PROJECT NAME: VOLLMER ROAD RV AND BOAT STORAGE
PROJECT ADDRESS: 8815 VOLLMER ROAD, COLORADO SPRINGS, CO 80908
PROJECT DESCRIPTION: SITE PLAN

SHEET TITLE: SITE DEVELOPMENT PLAN

FILE NO. PPR-2245

Site Development Plan_V2.pdf Markup Summary

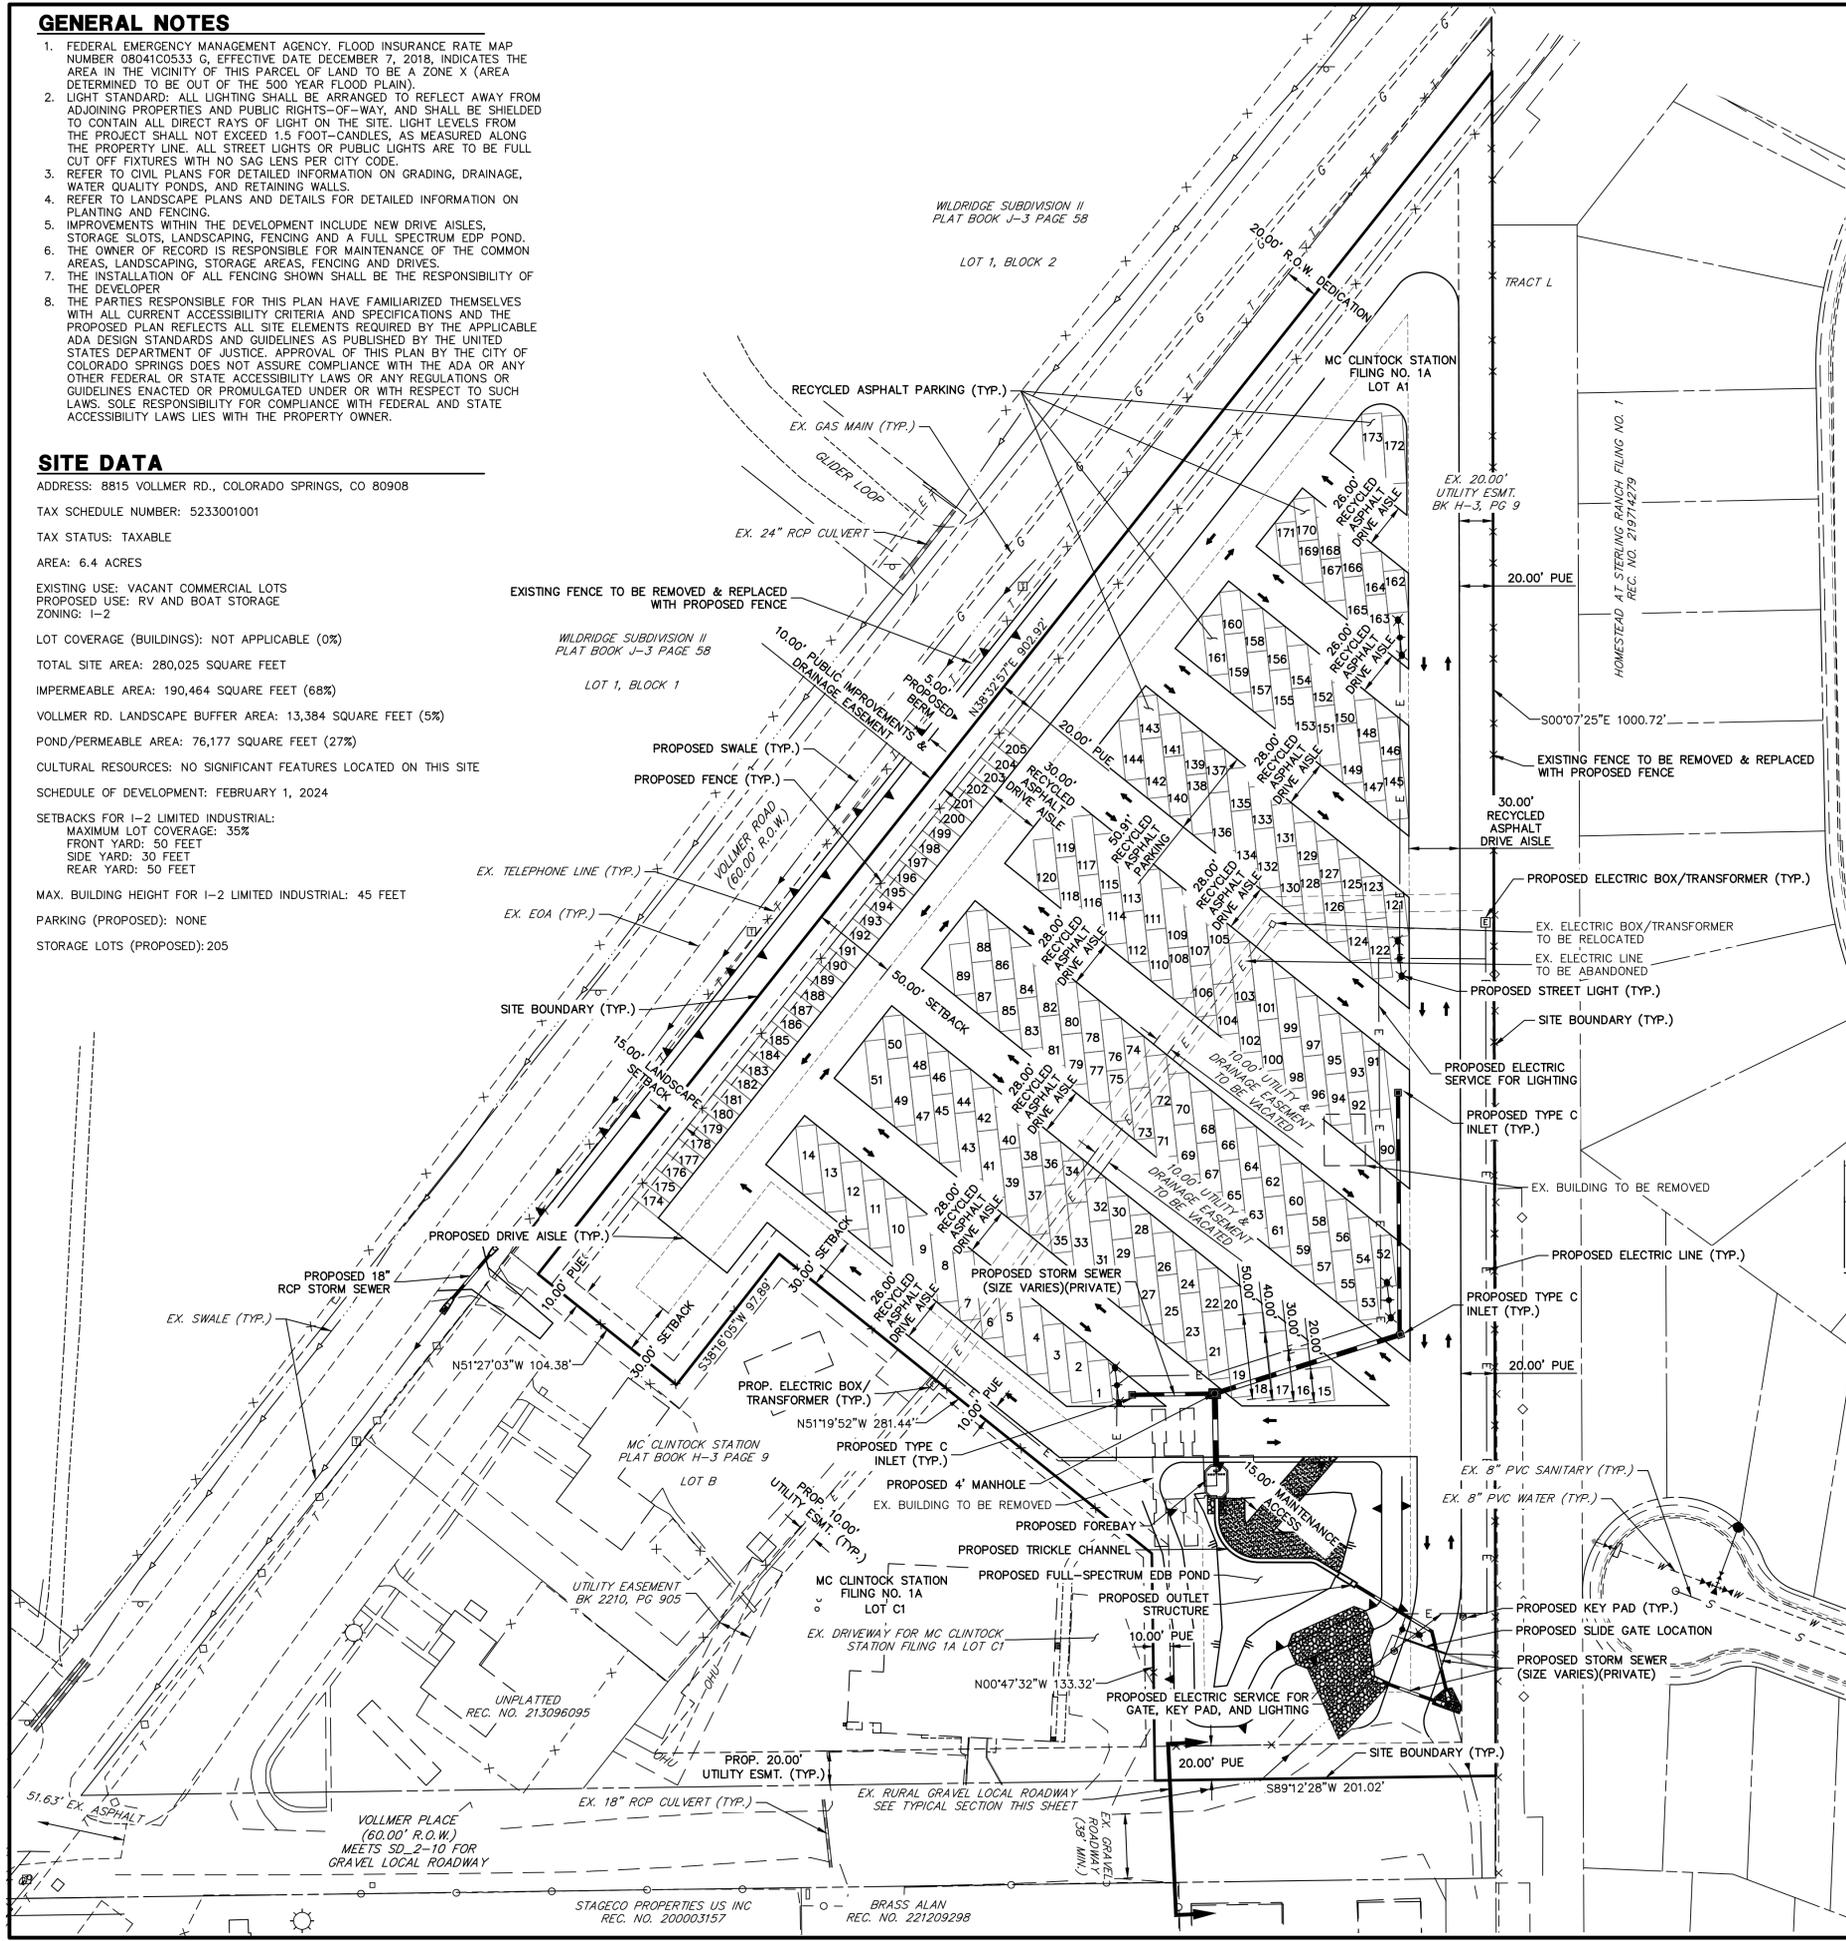
Label boundary line

Delete label - this is not boundary
